**From:** Bryan Bobrick [bryanb@iacivil.com]  
**Sent:** Wednesday, August 29, 2012 2:19 PM  
**To:** Olson, Greg R.  
**Cc:** AsaW@iacivil.com  
**Subject:** RE: C17-D120 Richfield Park Lot 5A "Verbal NO"

**From:** Olson, Greg R. [mailto:grolson@cabq.gov]  
**Sent:** Wednesday, August 29, 2012 10:57 AM  
**To:** AsaW@iacivil.com  
**Cc:** Olson, Greg R.; BryanB@iacivil.com  
**Subject:** C17-D120 Richfield Park Lot 5A "Verbal NO"

Per our phone conversation this AM, the Grading & Drainage plan for this site is generally acceptable, but cannot be approved until the following exceptions are addressed:

GRADING AND DRAINAGE PLAN

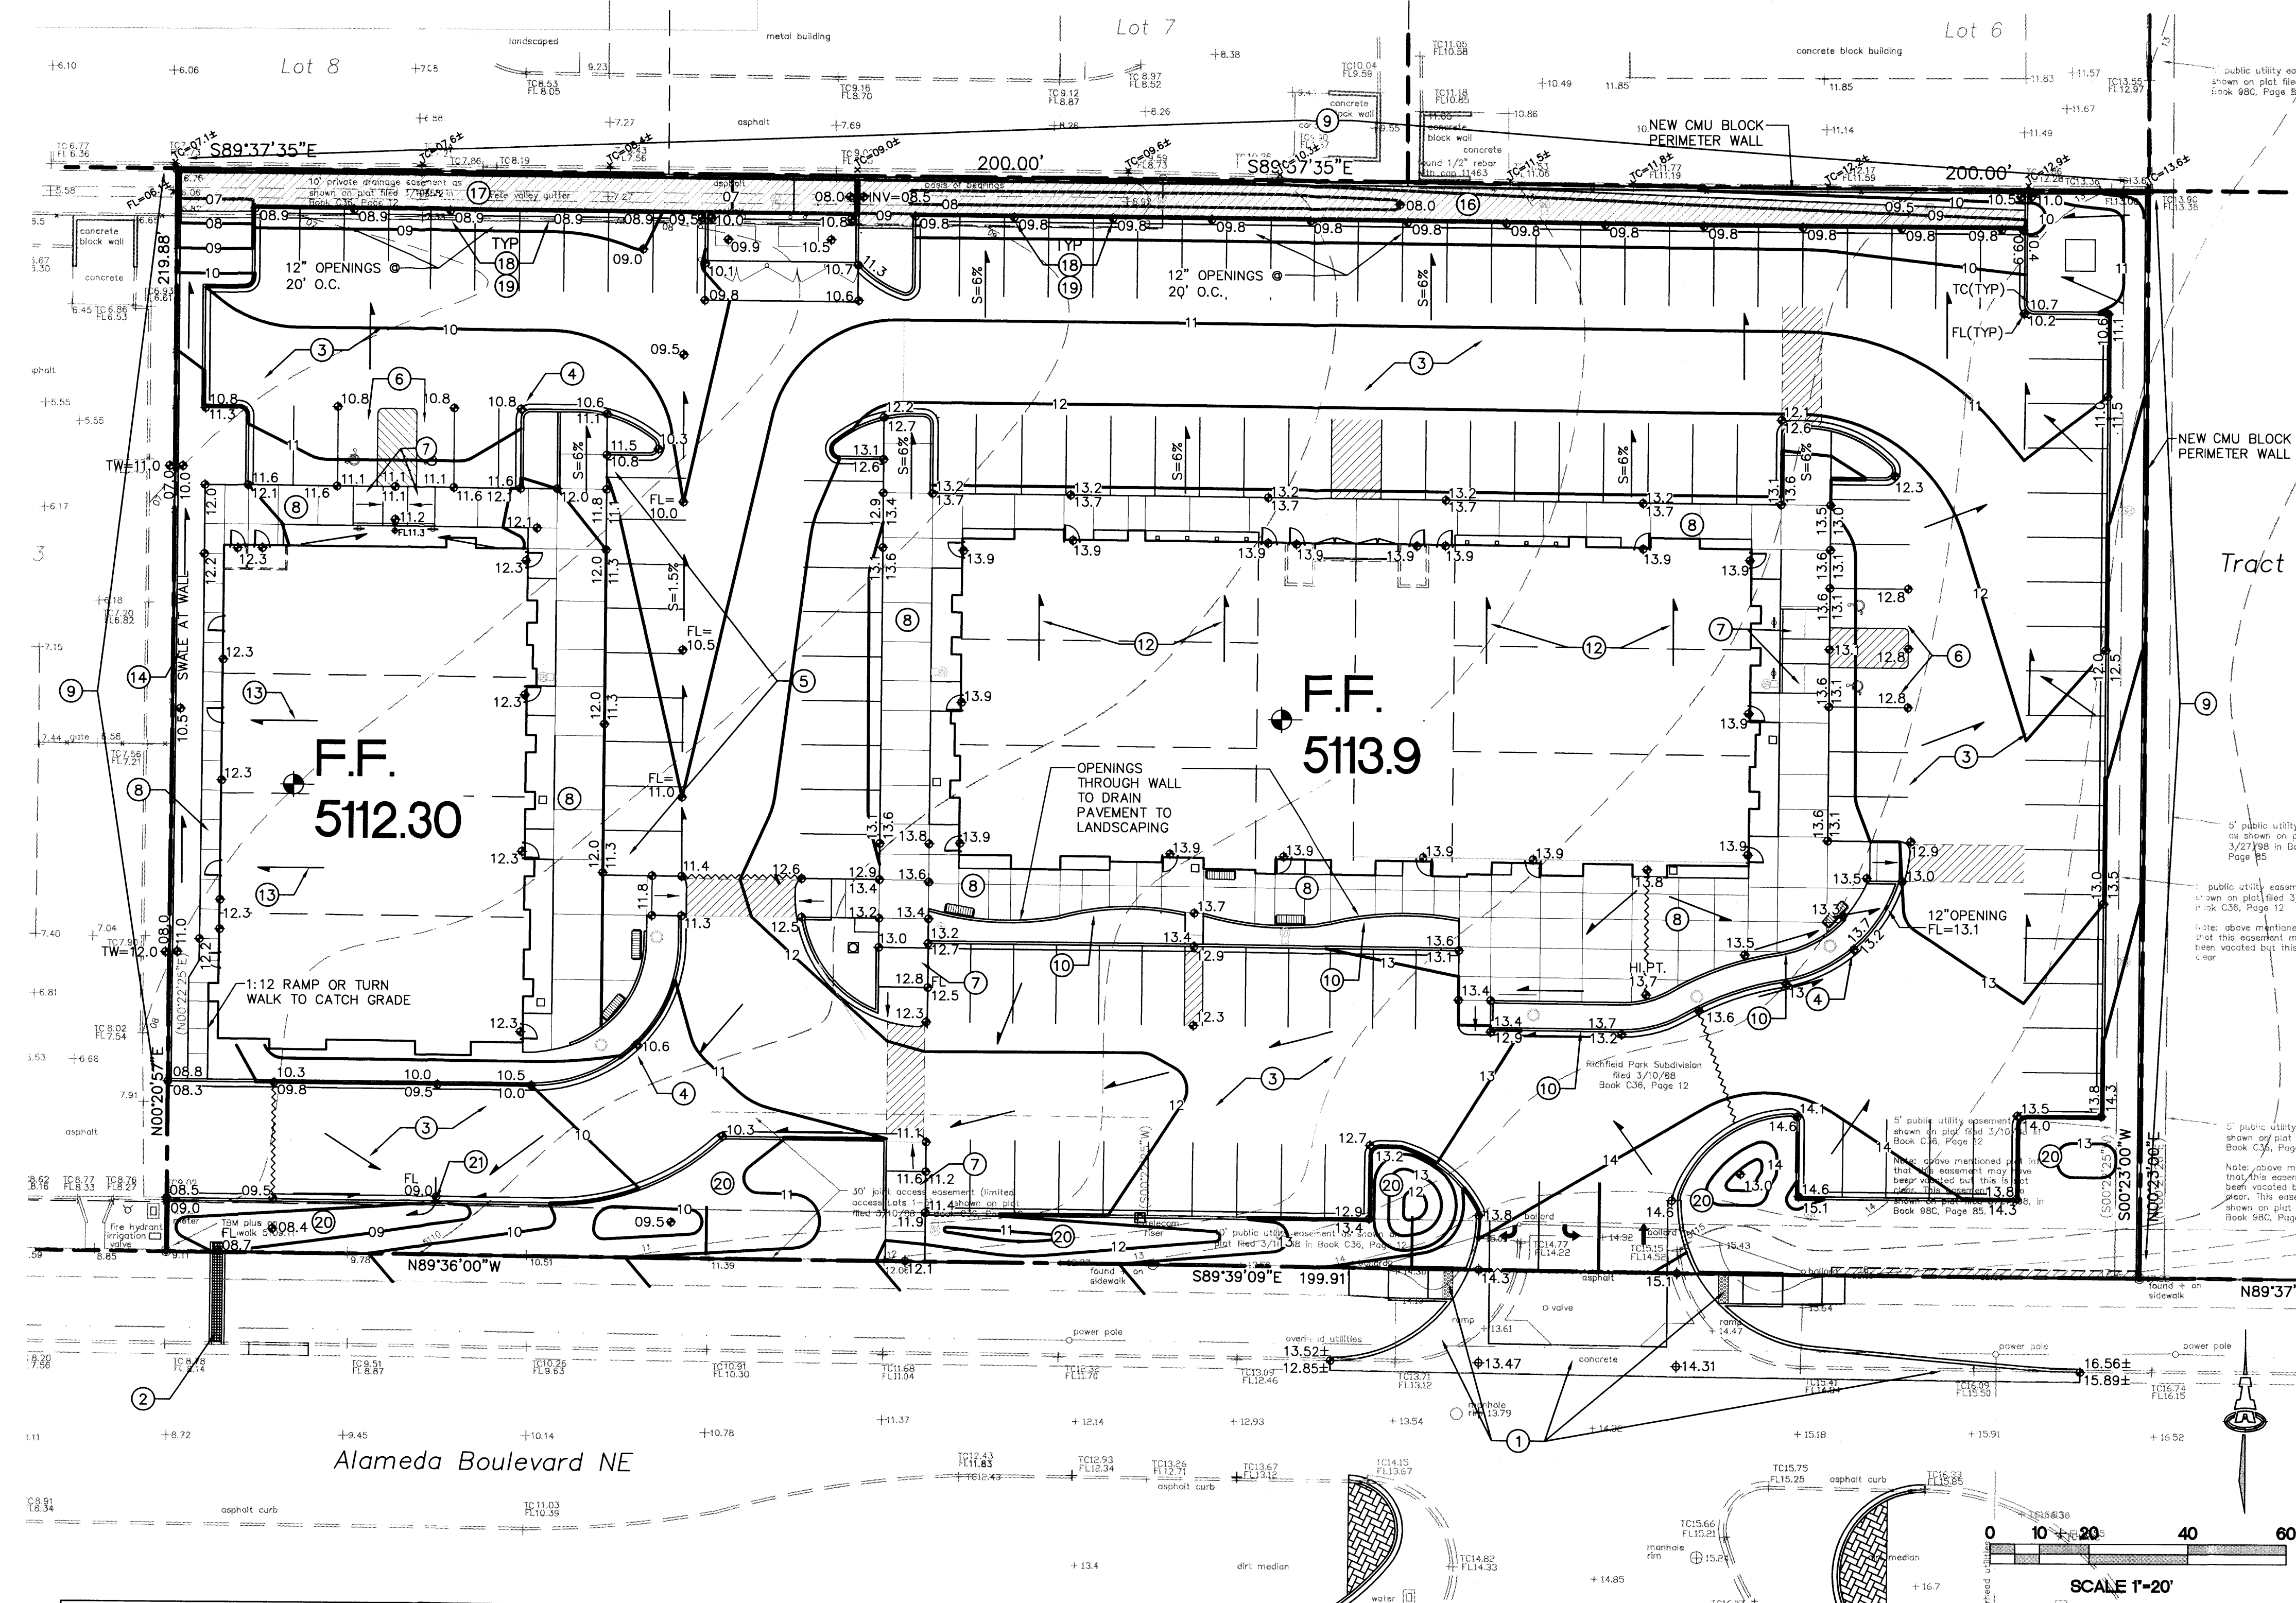
2. Address drafting details on the plans as follows:
  - a. Sh. CG-101: Key Note 2 should include a width for the Sidewalk Culvert.
  - b. Sh. CG-101: Provide Flow arrows in the swale along the west side of the lot.

- c. Sh. CG-101: Call out a curb opening and width at the low point in the driving lane south curb approx. 60' ENE of the SW corner of the site (at El. 9.0).

We have taken care of items 2a through 2d from your review comments. As part of the resubmittal, we included the attached photo (see below) in our response letter. This photo shows the adjacent property to the east has been 'developed' to some extent. We included the following explanation in our resubmittal letter:

1. The proposed wall on the east boundary appears to block offsite flows from Lot D1A, which may pond behind the wall, or be directed northerly along the property line. Contours shown suggest that these channelized flows (which by the Drainage Master Plan should go to Columbine Road) may cross over into the east side of Lot 6, north of your site. Provide more detail as to how these offsite flows will be routed after construction of the wall. If offsite grading is required to deal with this situation, we will require written permission from the owners of the offsite parcel(s).

1. No offsite flow passes to the property from the east. The photo below shows the east property graded with asphalt millings to serve as an overflow parking area (by others). A deflection berm at the joint property line deflects sheetflow to the north to follow the required drainage path for Parcel C1-D. In addition, a perimeter wall proposed as part of the Lot 5A construction which will also serve to deflect offsite flow.

The existing topo contours show a minor slope from south to north. The photo shows a small deflection berm. In addition, I have discussed the concern with John Mechenbier and he has agreed to waterproof the bottom rows of blocks. Will this suffice?

HEADWALL A: BETWEEN PONDS 1 AND 2

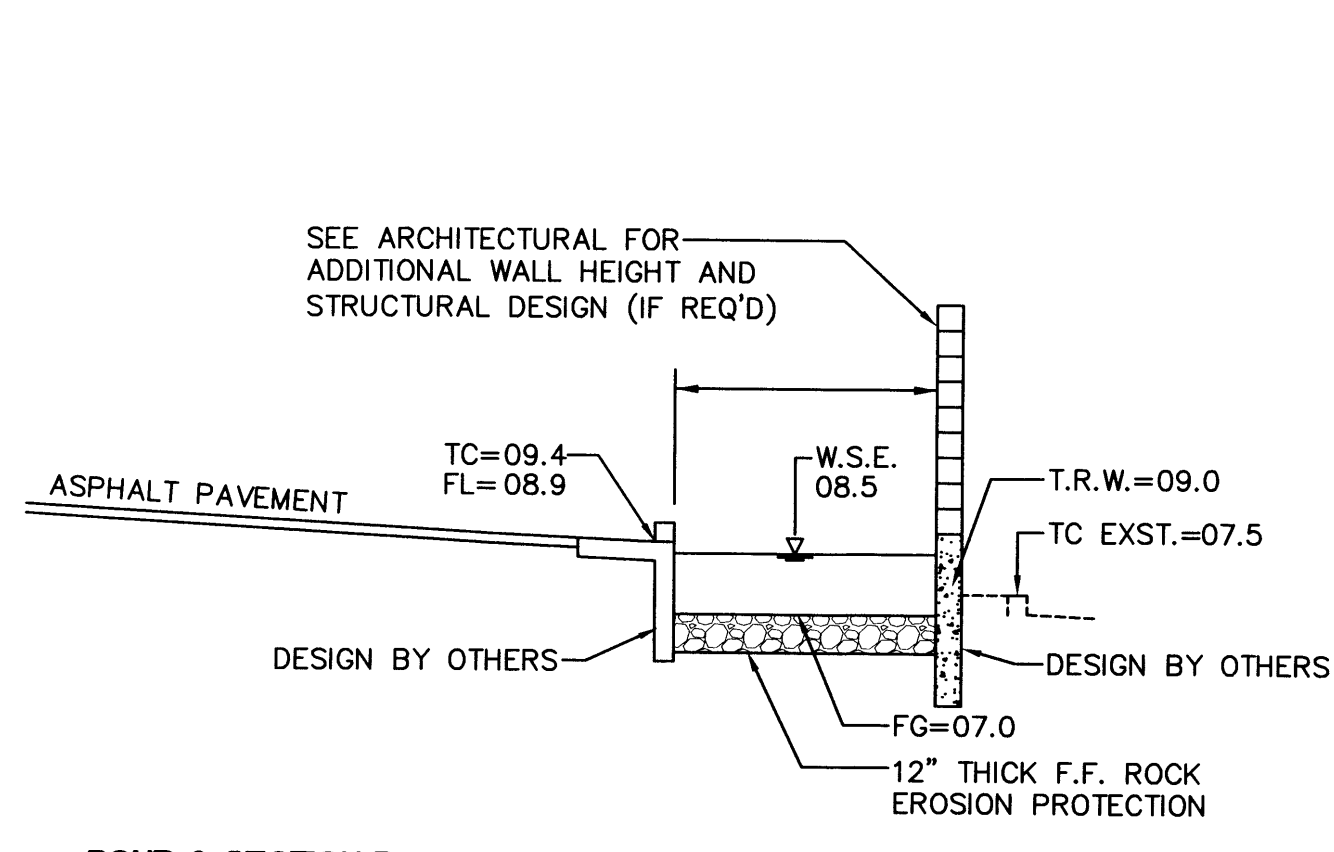
- d. Sh. CG-501: The lower of the two Headwall A Details appears to represent Headwall B.  
Please clarify/re-label.
